WEST SUSSEX COUNTY COUNCIL CONSULTATION

TO:	Arun District Council FAO:Andrew Wood
FROM:	WSCC - Highways Authority
DATE:	26th March 2019
LOCATION:	Quiet Waters Roundstone Lane Angmering BN16 4AX
SUBJECT:	A/26/19/PL Application for variation of condition of condition following grant of planning permission A/132/17/OUT relating to condition no. 20 - Electric Vehicle Charging Points.
DATE OF SITE VISIT:	
RECOMMENDATION:	Advice
S106 CONTRIBUTION TOTAL:	N/A

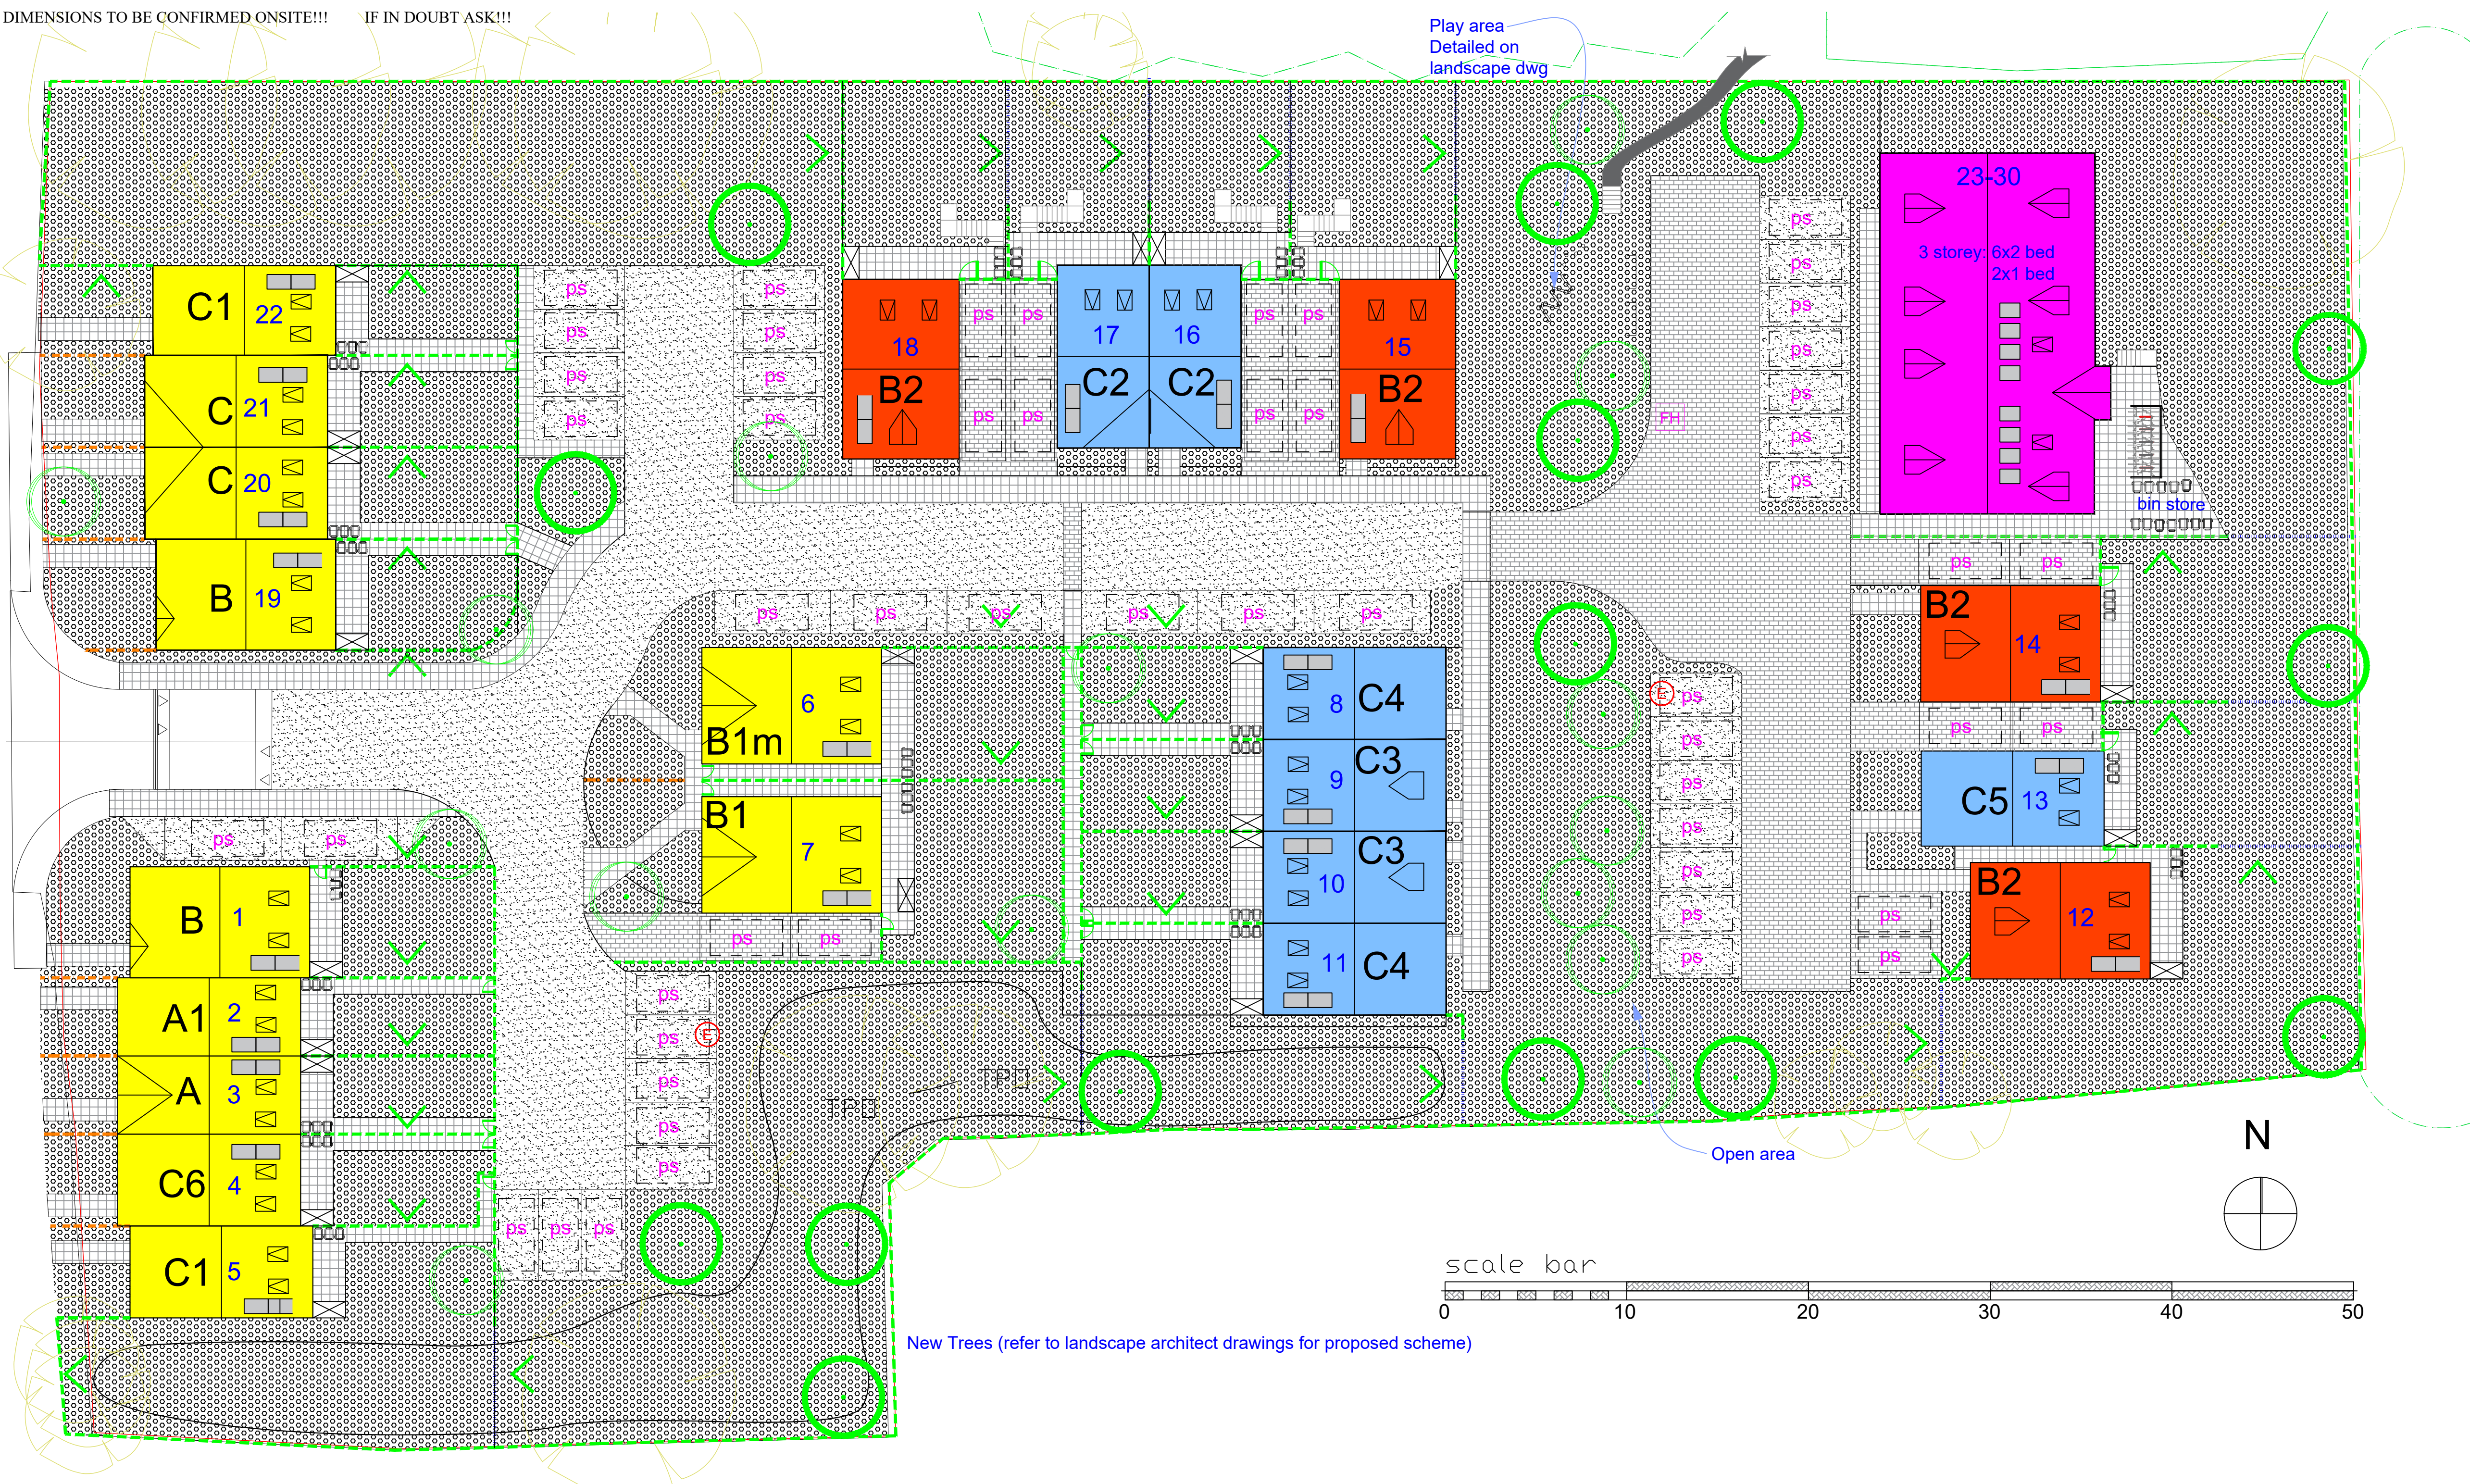
The application is seeking to vary Condition 20 as follows: 'Electric Vehicle Charging Points Shall be provided in accordance with Electric Vehicle Charging Points Plan (Southmill-1006-ANG002)'. Based on the information submitted there is insufficient infrastructure in place for all houses to have charger systems. There is however sufficient load capacity for 2 charging points within the site.

The LHA would not have any concerns with the proposed variation of Condition based on the information submitted.
